Our Ref: EN020028

Date: 18 November 2024

Application by Morgan Offshore Wind Limited and Morecambe Offshore Windfarm Limited for an Order Granting Development Consent for the Morgan and Morecambe Offshore Wind Farms Transmission Assets project

Advice following issue of decision to accept the application for examination

Statutory and Non-Statutory Features of (The Offshore) Historic Environment Plan (Doc B17)

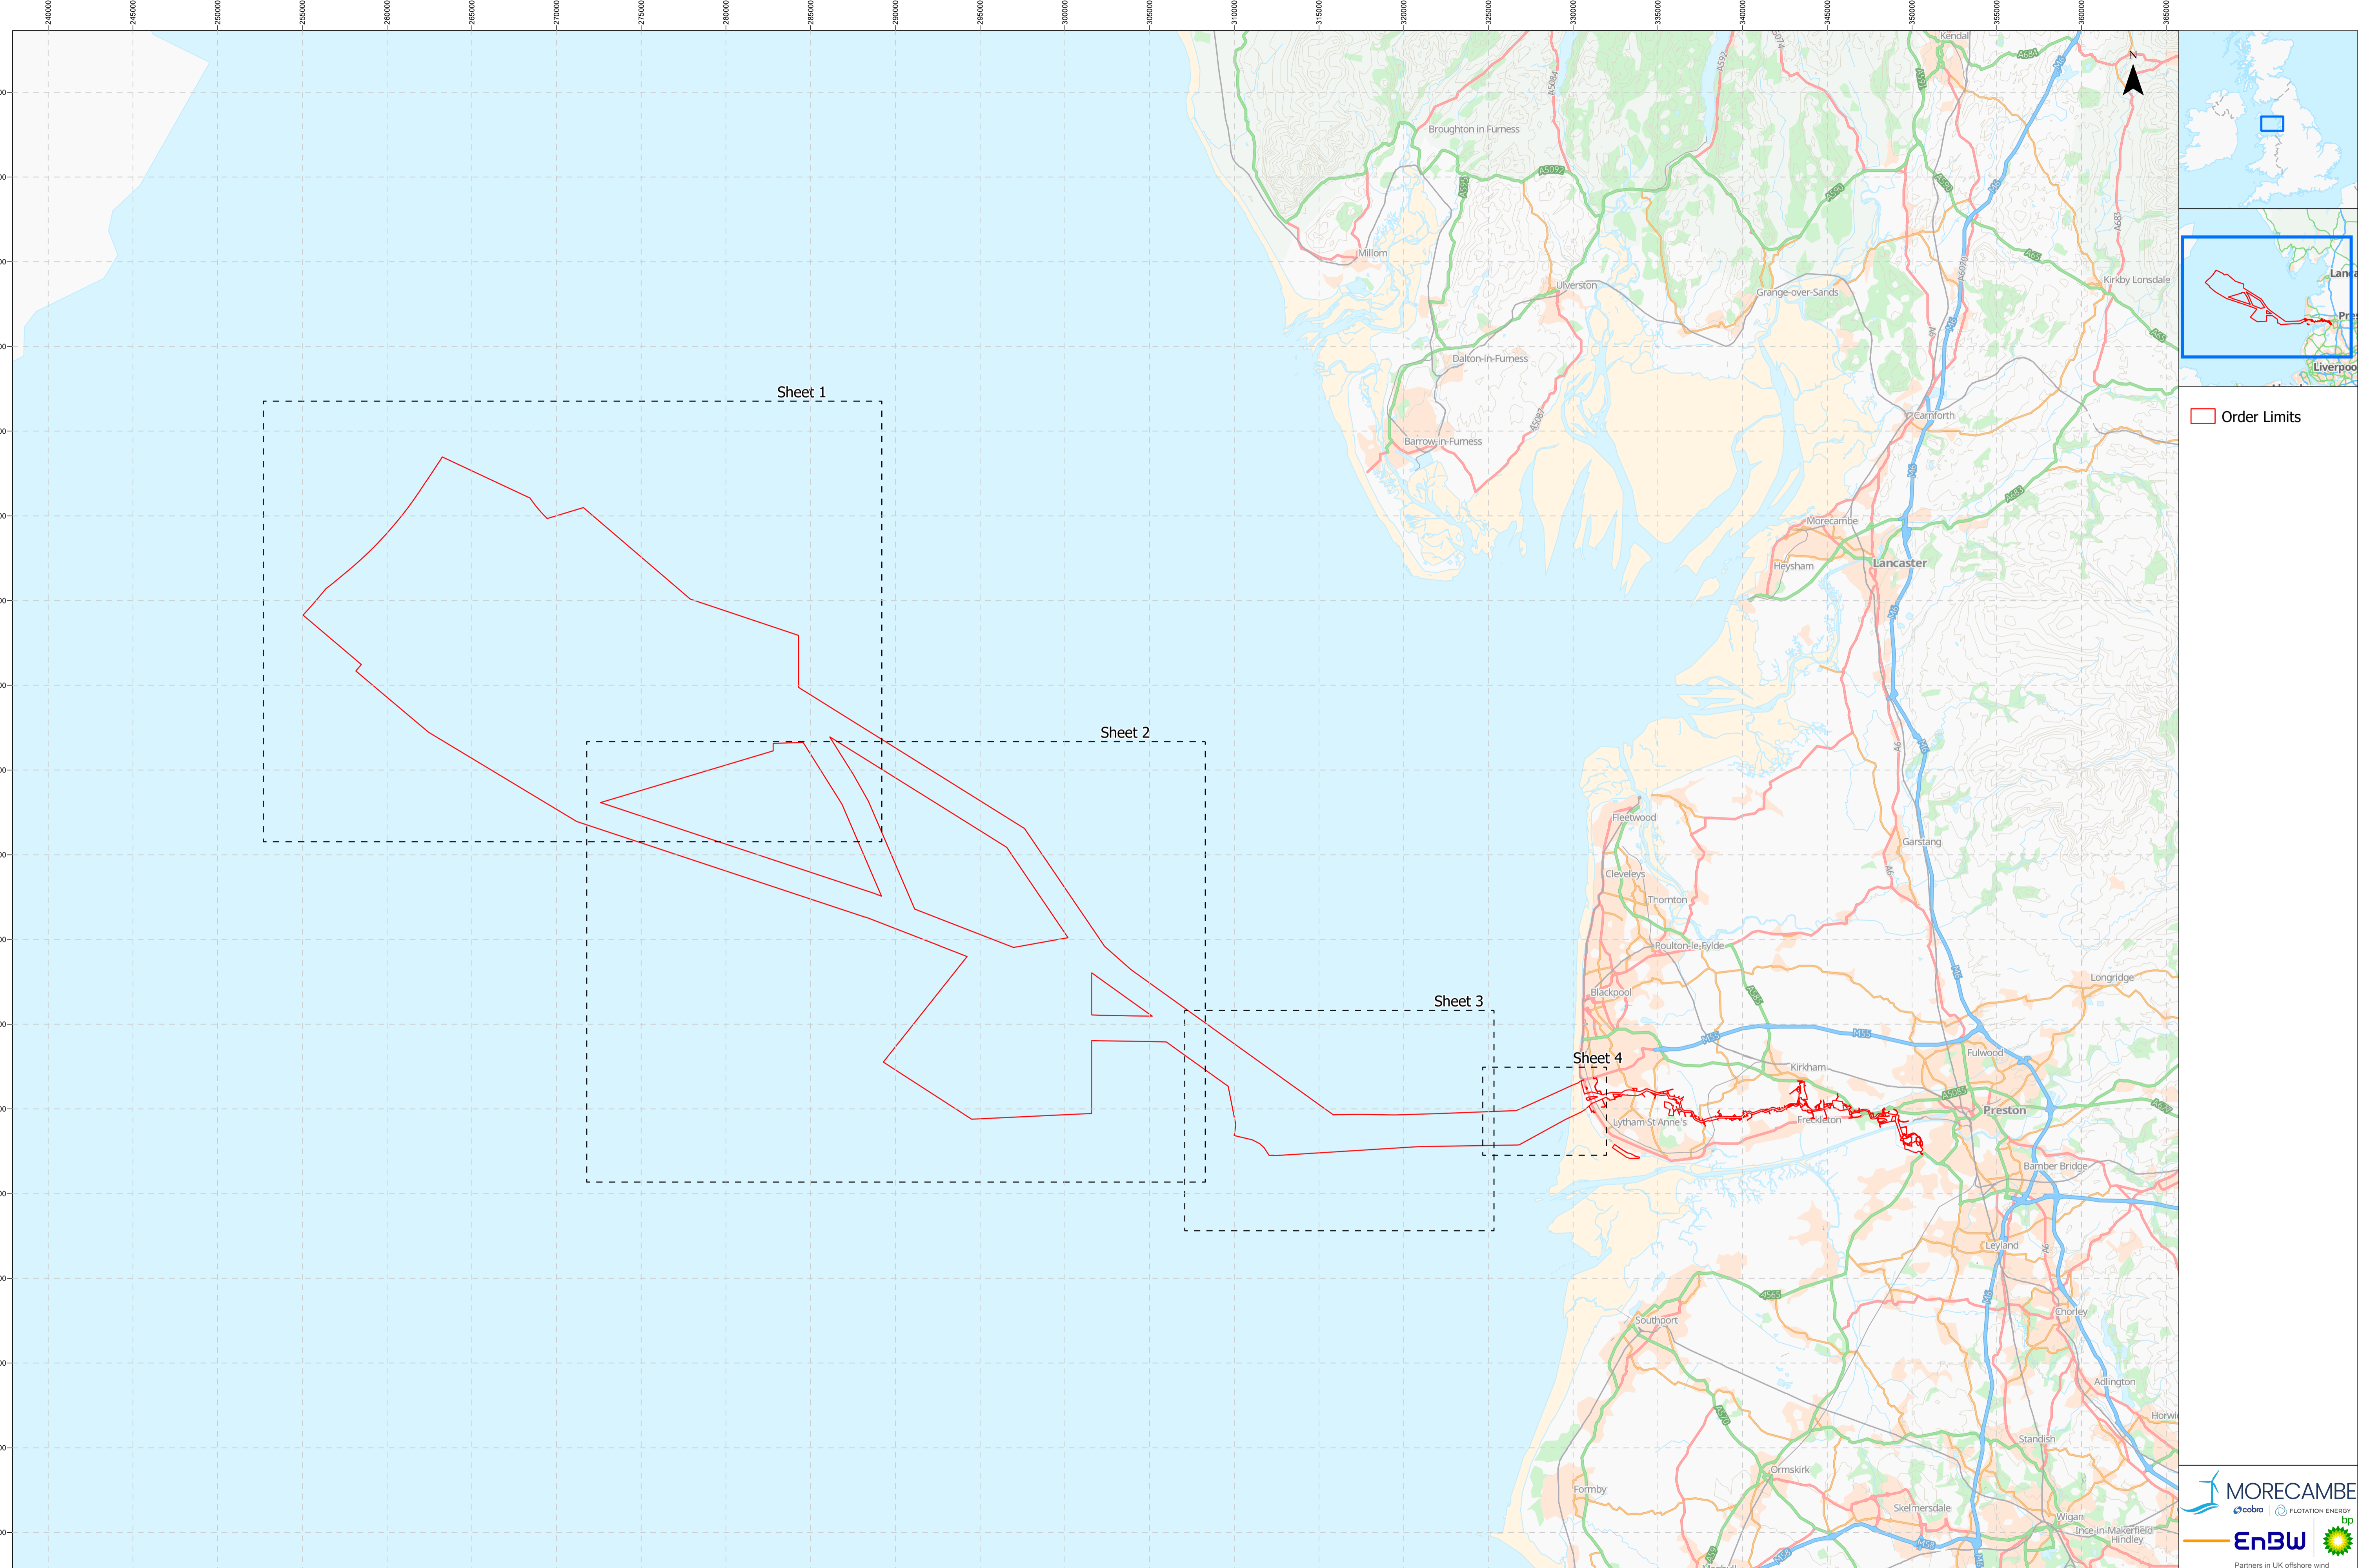
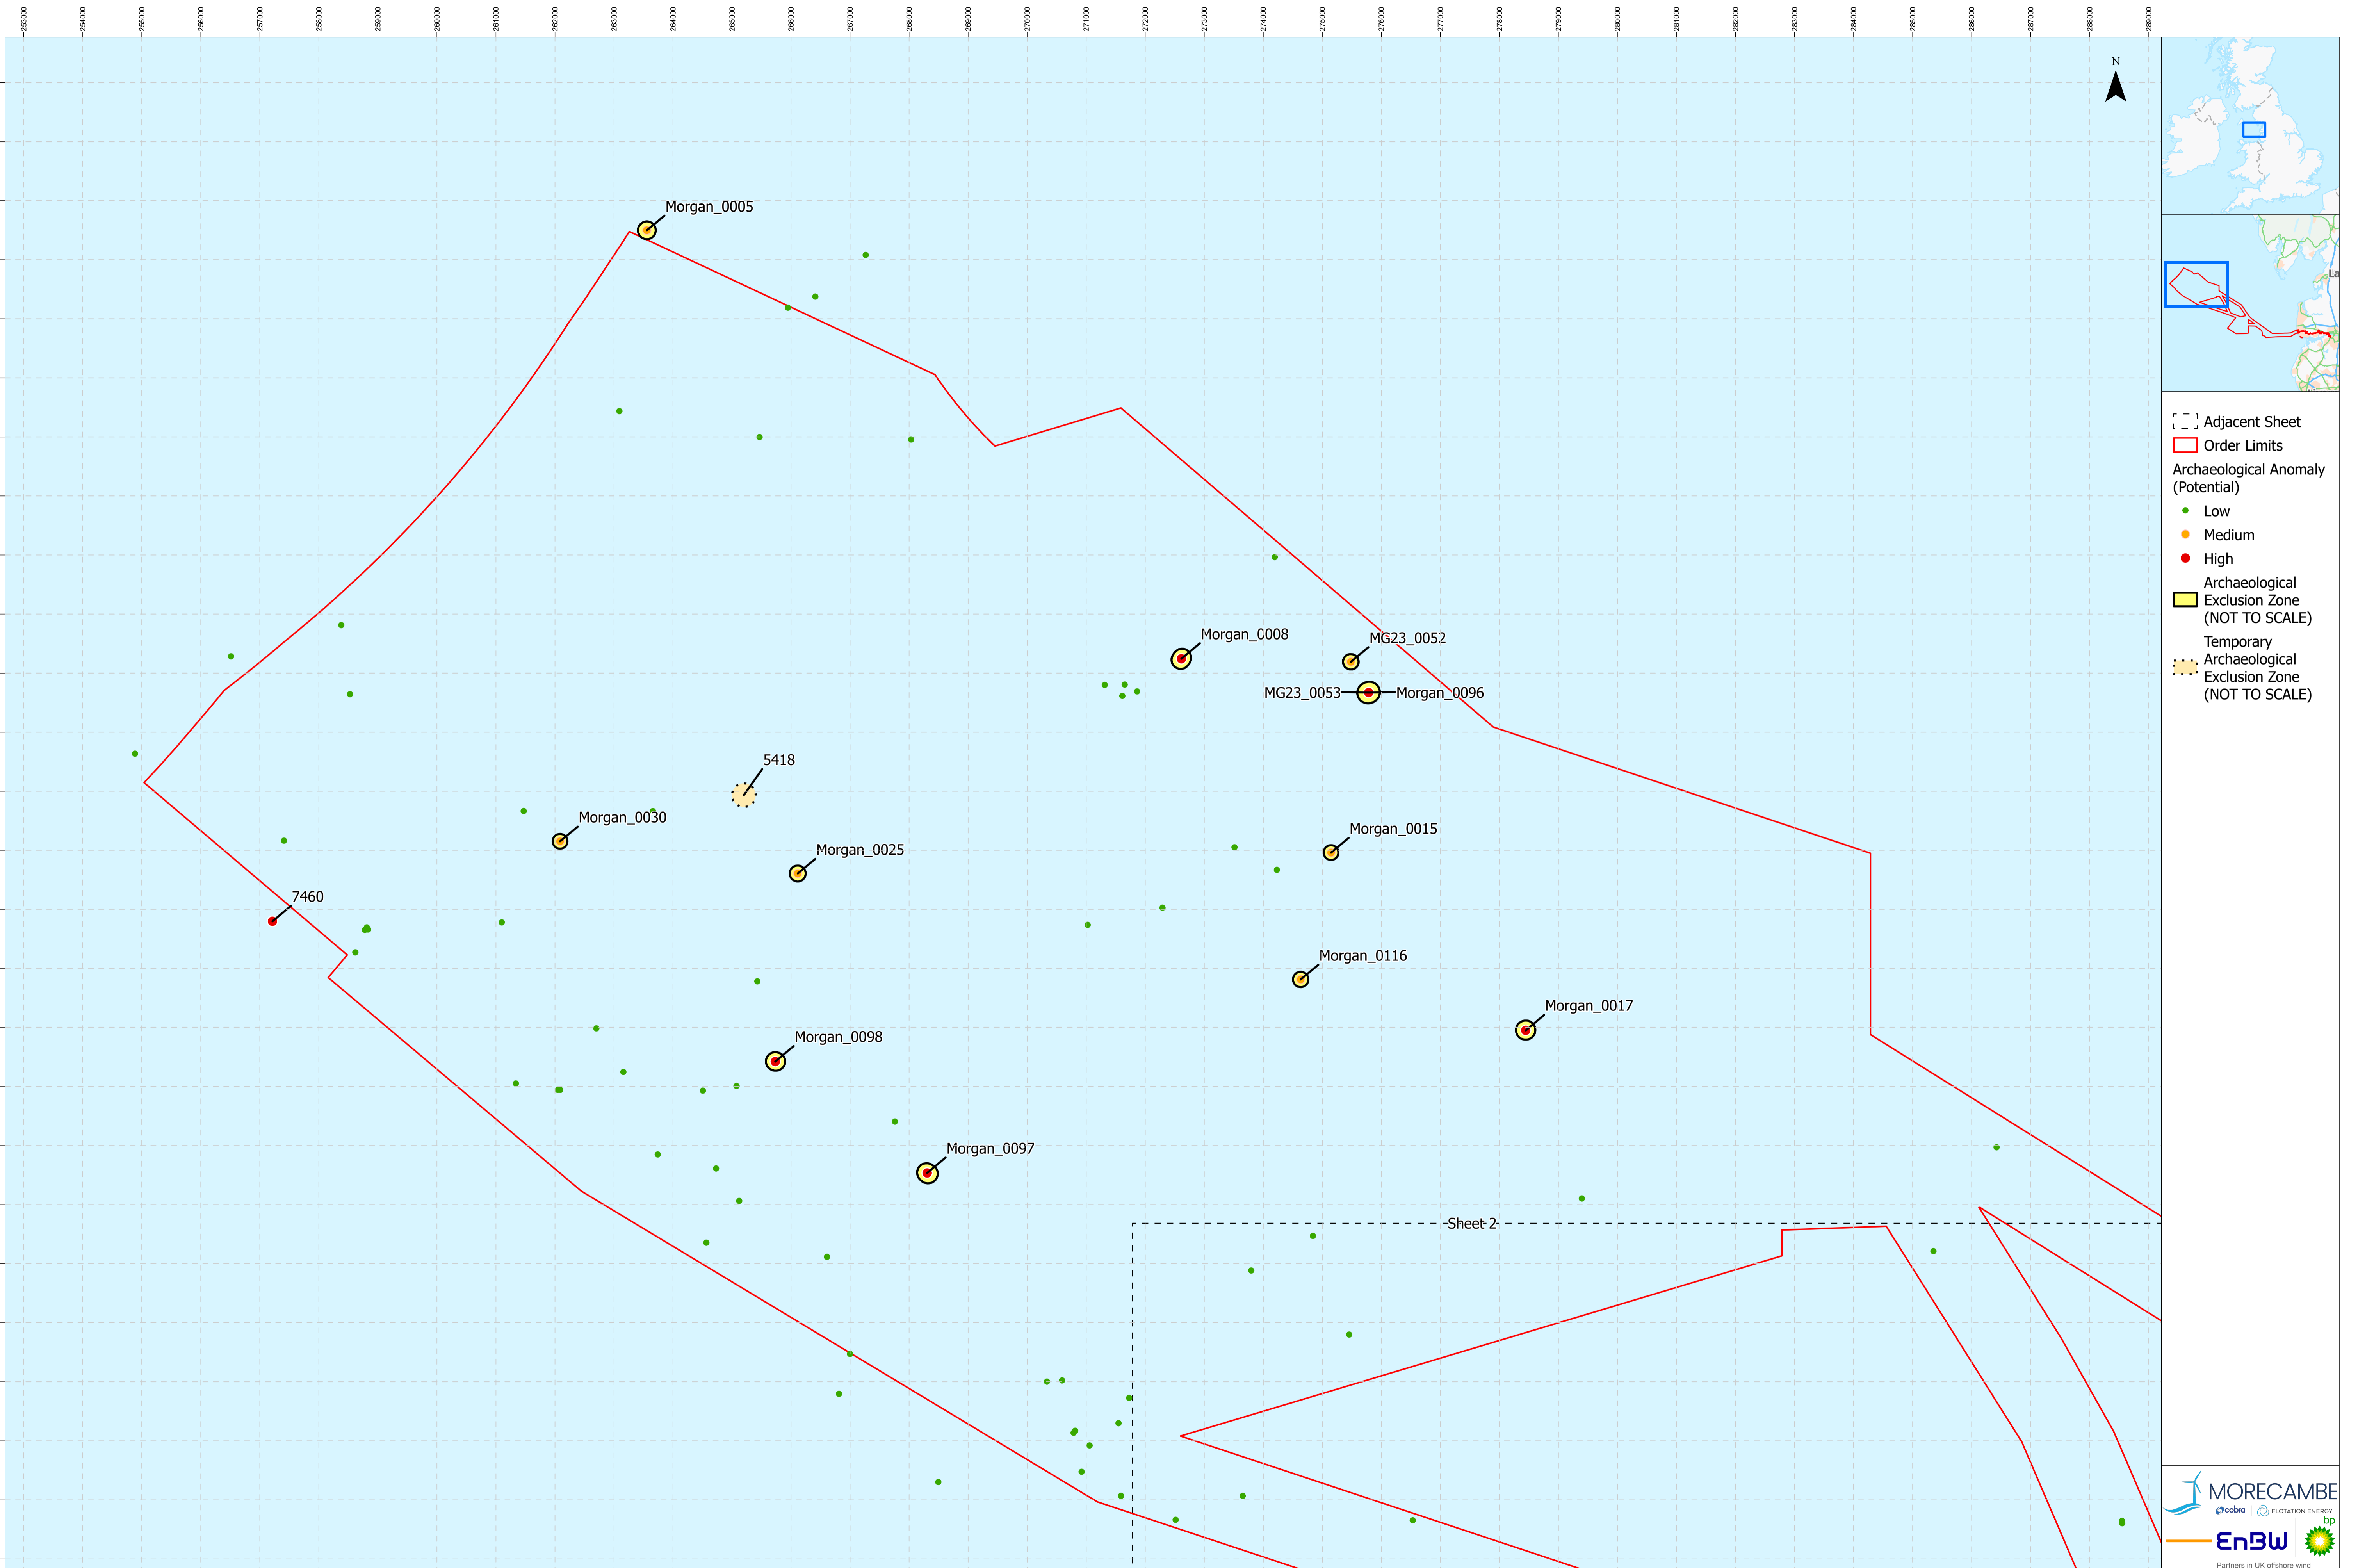
Standalone figure B17 (Statutory and Non-Statutory Features of (The Offshore) Historic Environment Plan) only shows offshore exclusion areas rather than specific features, however the specific sites are shown on the ES figures. The Applicants are advised to provide an updated set of figures with appropriate labelling of the features being represented.
